17th December 2019

**Application by Norfolk Boreas Limited for the Norfolk Boreas Offshore
Windfarm
Response to Deadline 3
Planning Inspectorate Ref: EN10087
Our Registration ID: 20022672**

We offer the following response to those questions directed at Archaeology and Cultural Heritage as set out within First Written Questions (dated 19th November 2019) and addressed by the Applicant.

Geophysical anomalies and exclusion zones

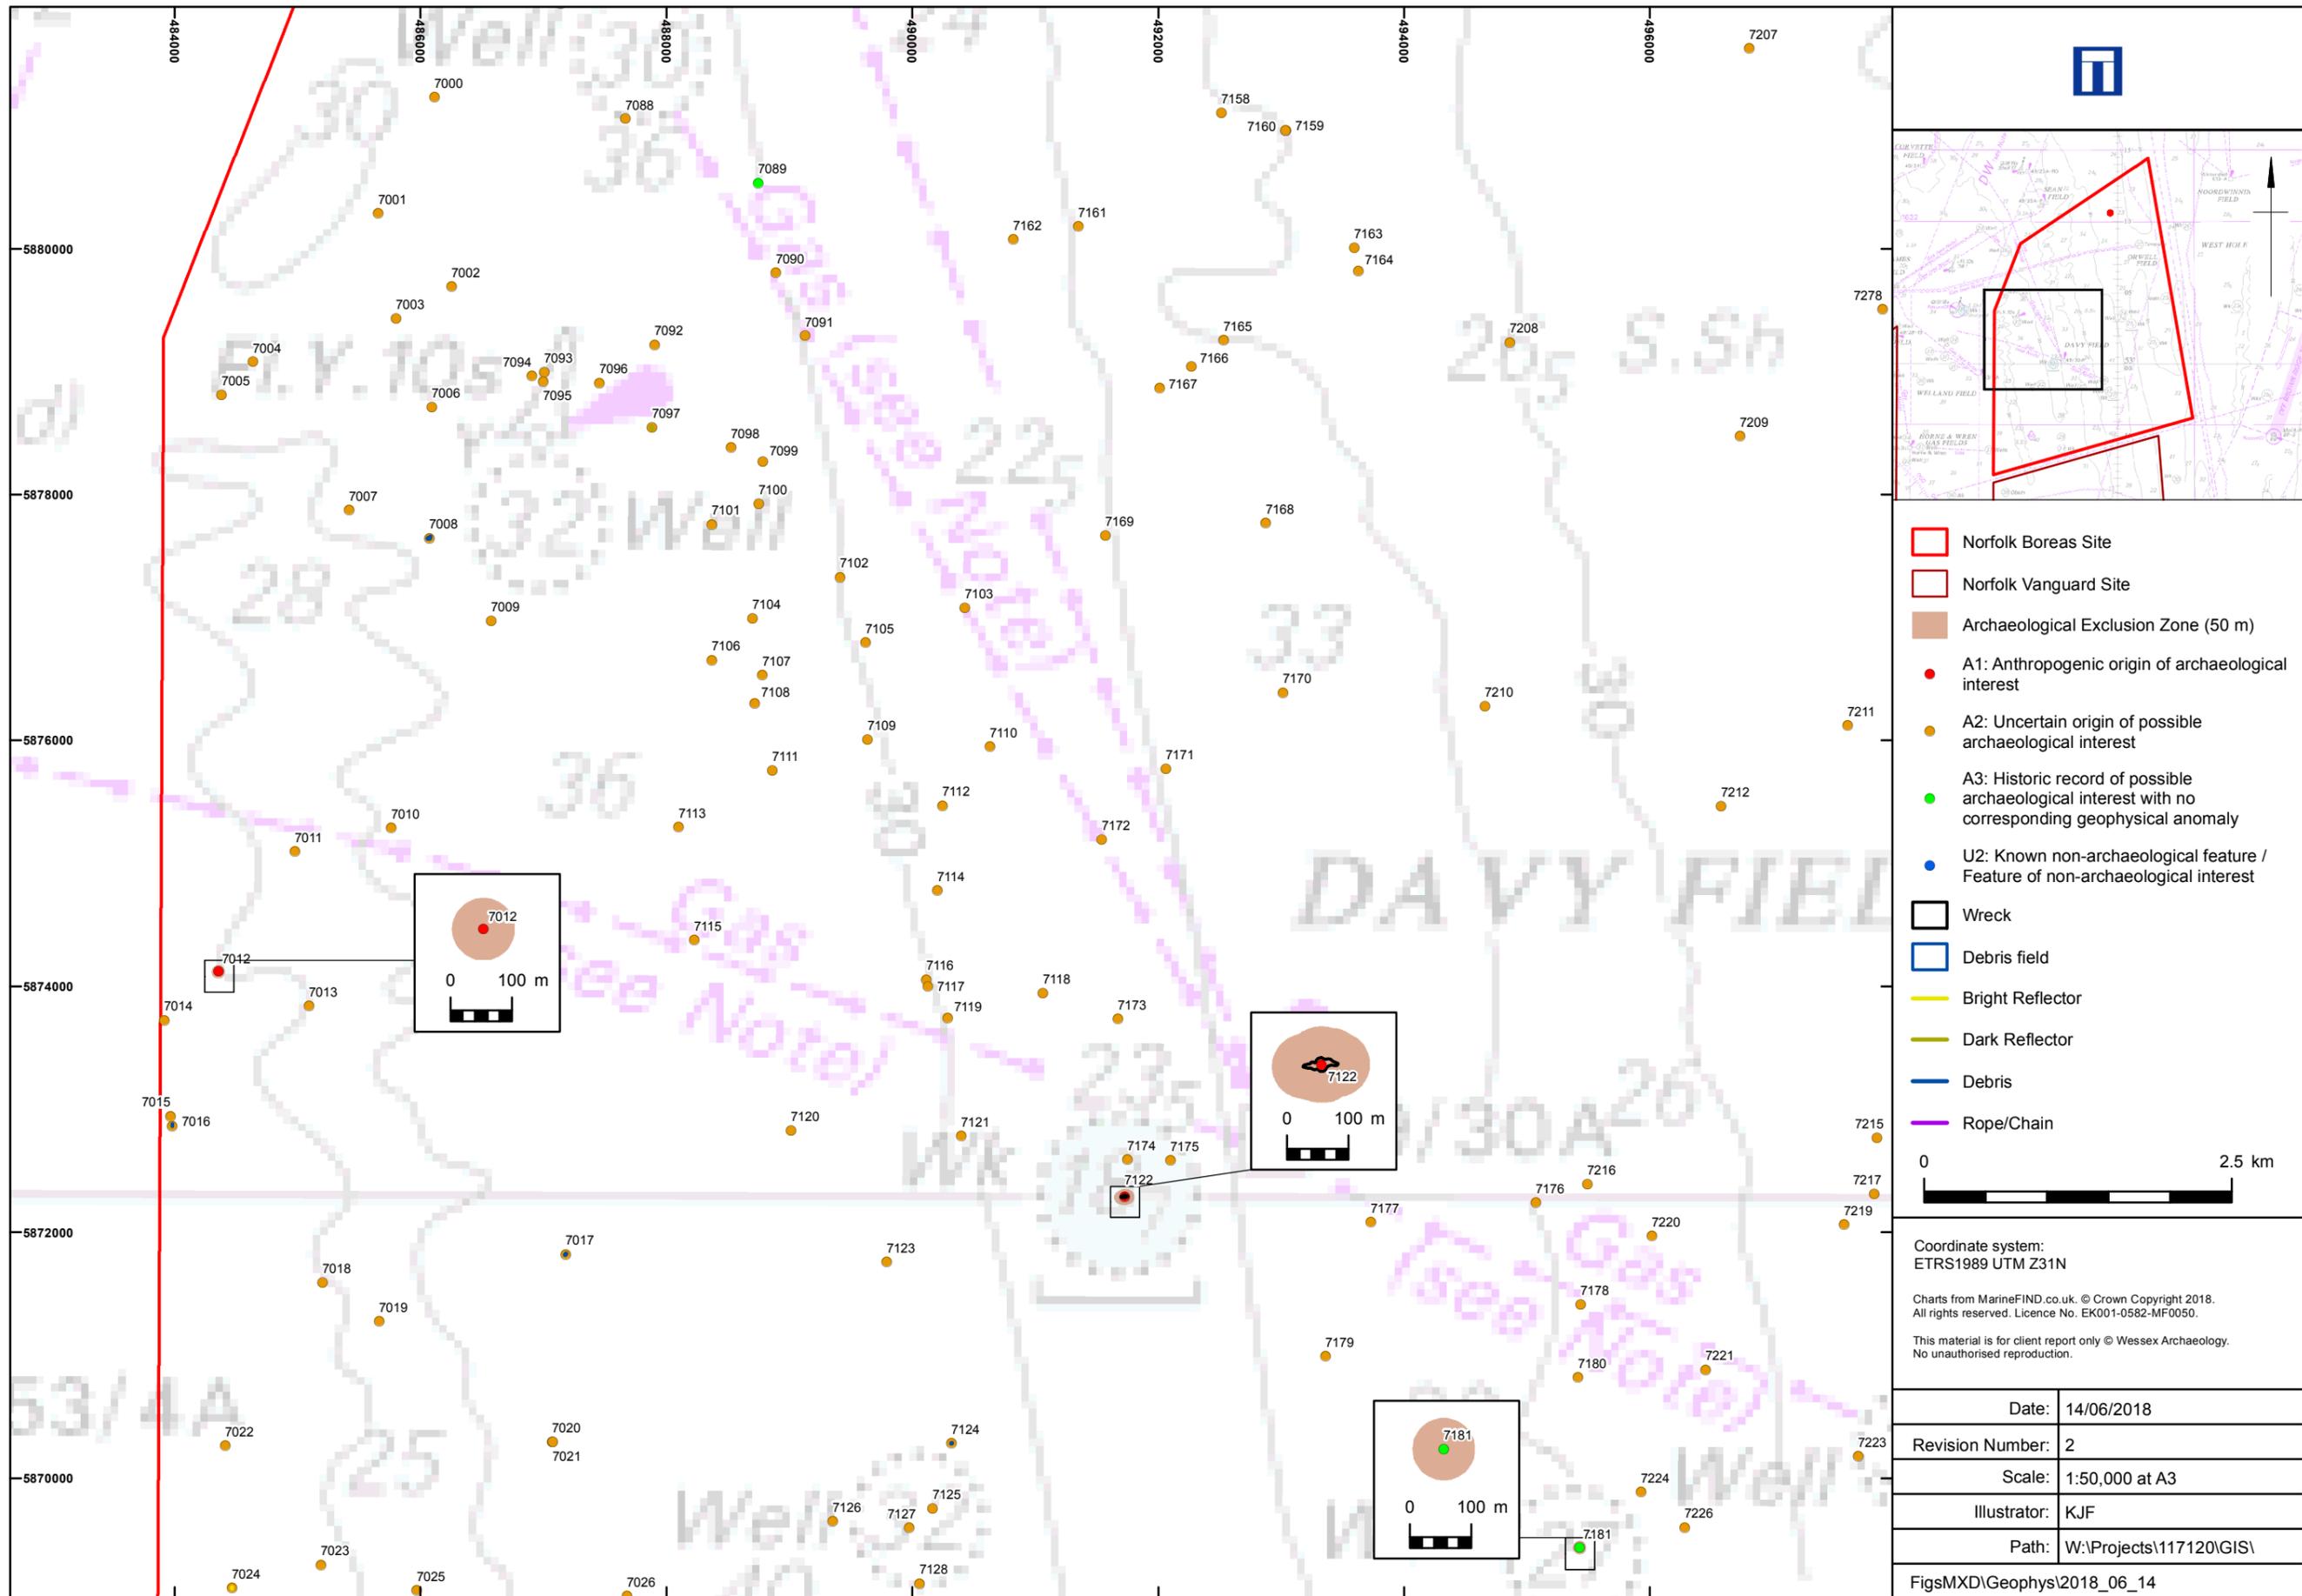
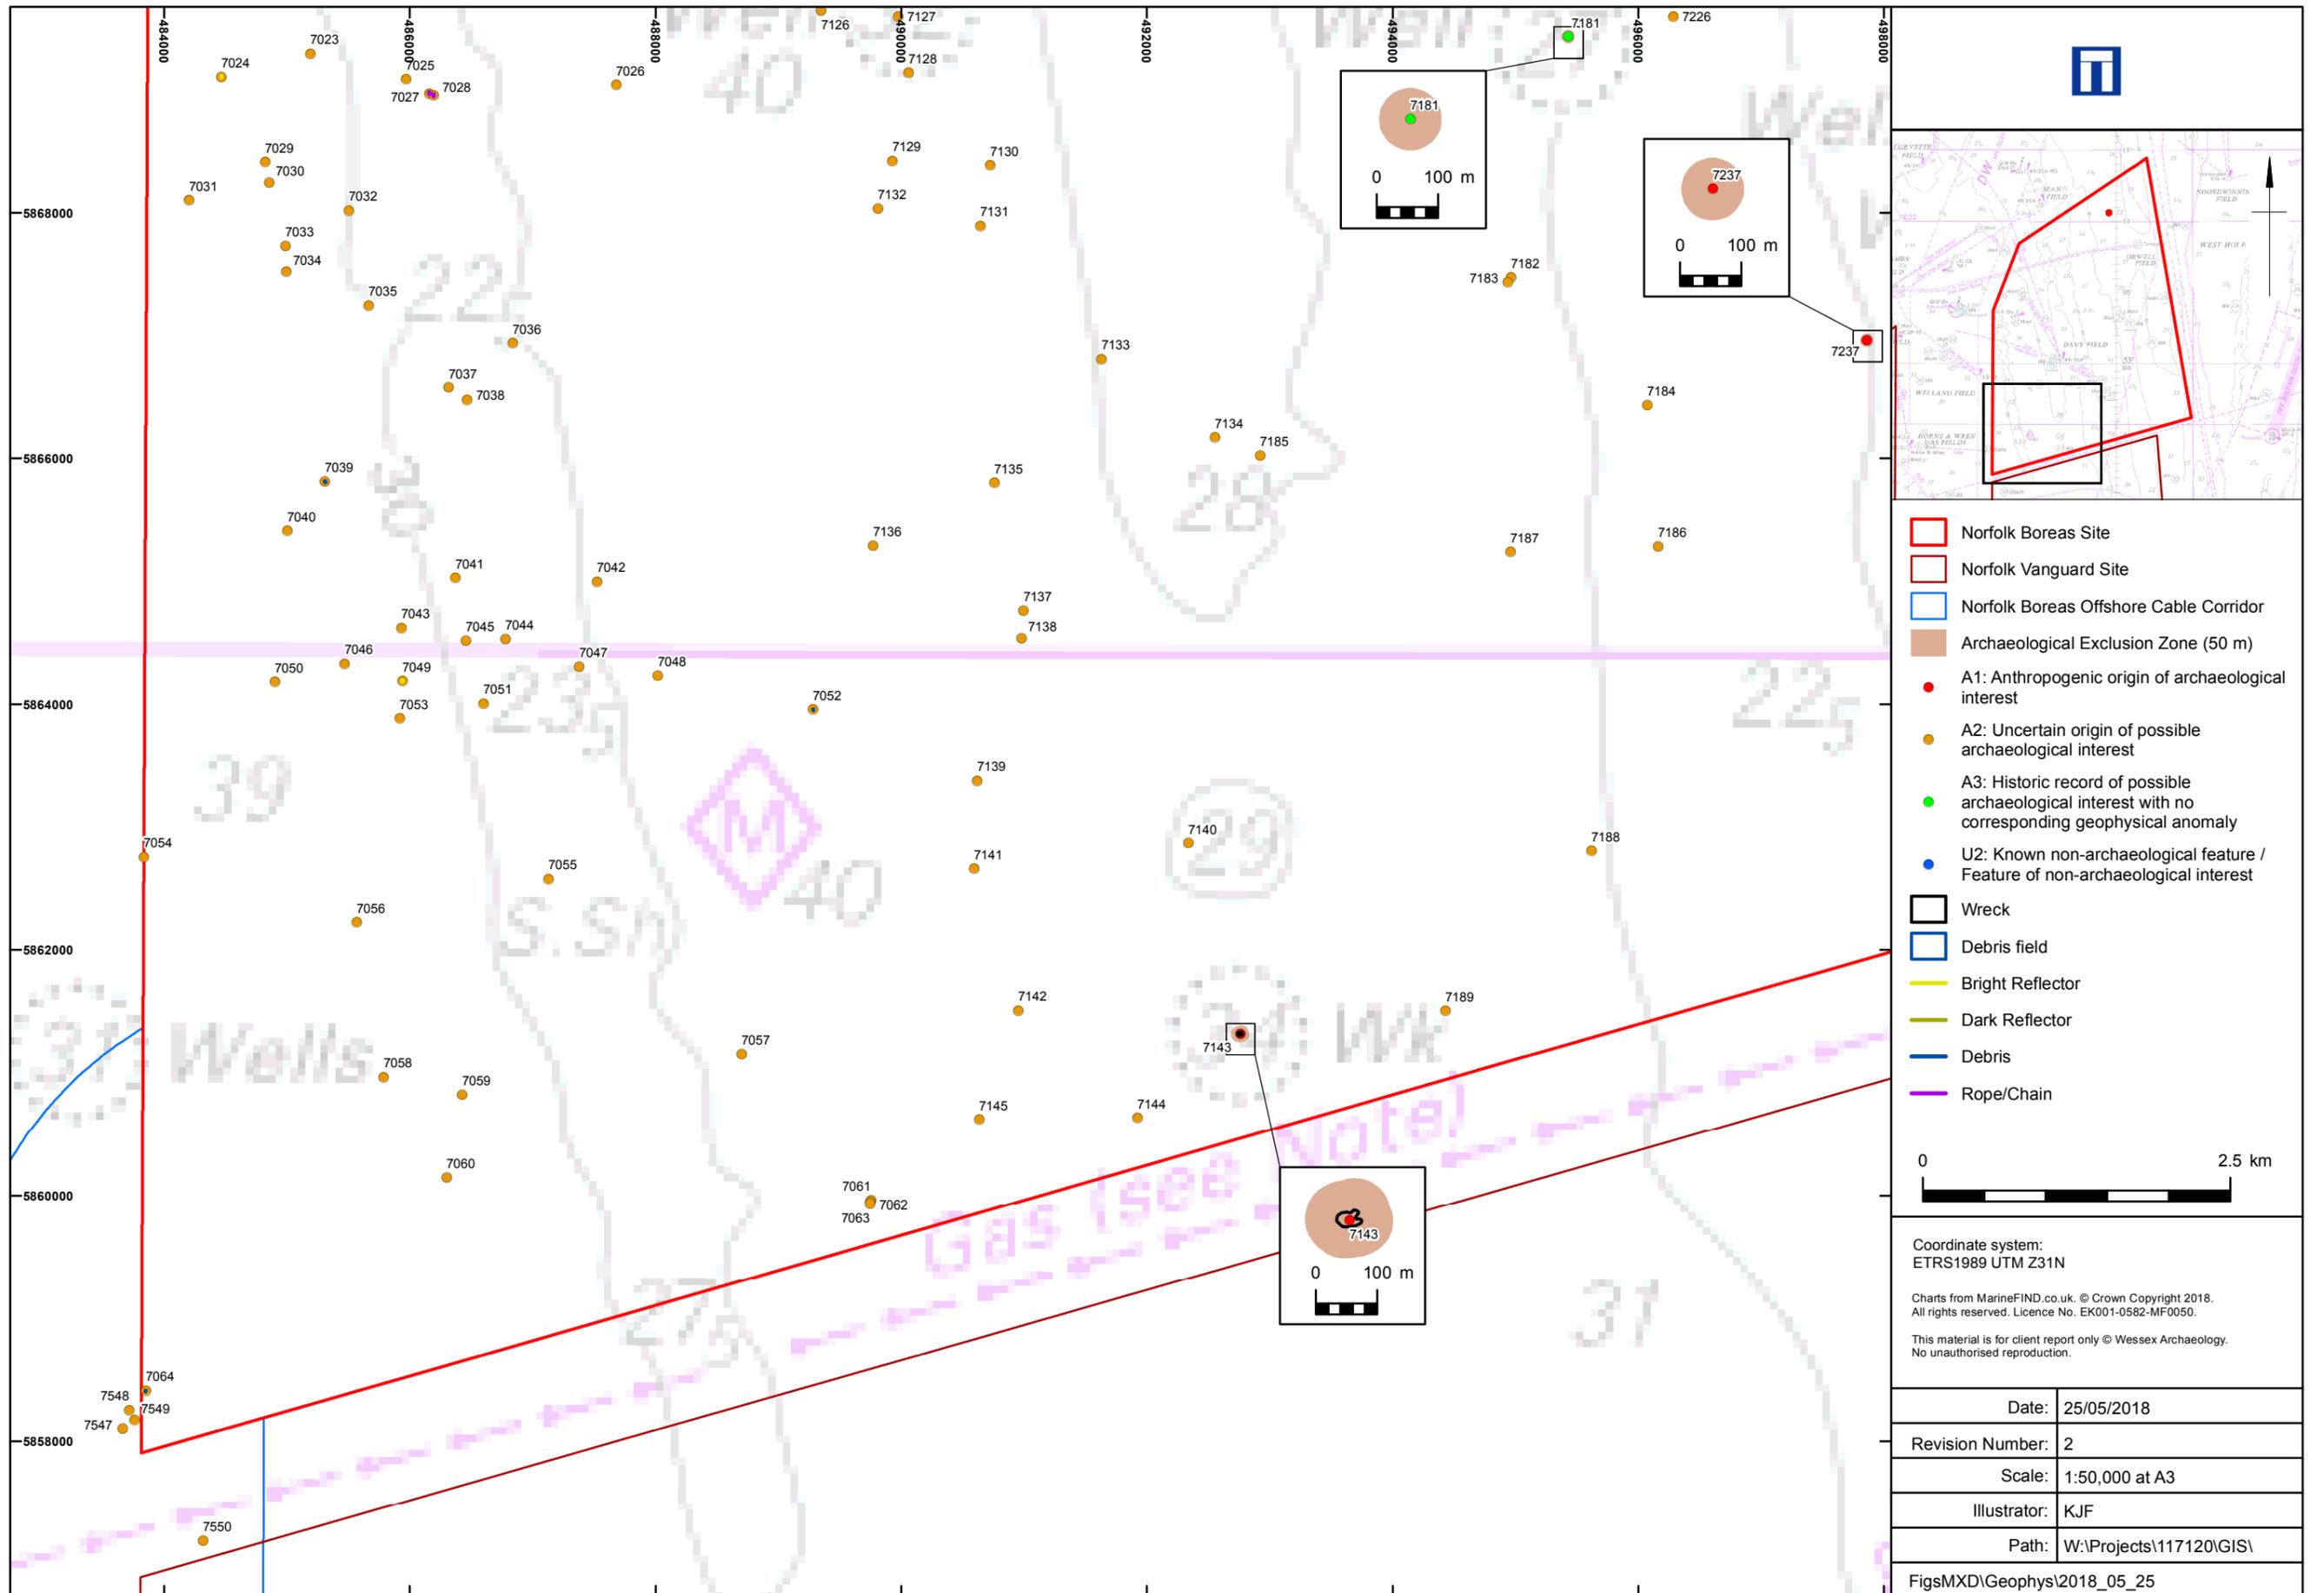
Response: The use of Archaeological Exclusion Zones (AEZs) is in recognition of different seabed development activities and their associated risk to either known or unknown elements of the historic environment as might be present. The primary function in the use of AEZs is as a mitigation measure to provide in-situ protection and therefore the spatial scale of an AEZ will vary on a case-by-case basis. It is therefore important that the archaeological Written Scheme of Investigation (WSI) produced from the outline WSI included within the DCO application explains how AEZs are identified, mapped, monitored and included within other relevant project delivery documentation used by the Consent Holder, contractors and sub-contractors (e.g. *Offshore In Principle Monitoring Plan*, DCO Document: 8.12, version 1, dated June 2019). In reference to the two designated historic shipwreck sites that exist within the proposed development Order Limits:

- The *Seagull* (Feature ID: 70809¹); and
- *Xanthe* (Feature ID: 70834)

It is important to offer the correction to the Applicant's response that these are now scheduled monuments and afforded statutory protection through the provisions of the Ancient Monuments and Archaeological Areas Act 1979. We also confirm that the List Entry for these two designated sites is available, as per the web links provided in our letter, dated 10th December 2019 (response to First Written Questions) submitted for Deadline 2. The List Entry also spatially defines the scheduled area, for both these designated heritage assets, as 100m in radius and therefore the minimum spatial extent of any AEZ must be amended to accordingly within any offshore archaeological WSI produced post-consent, should permission be obtained.
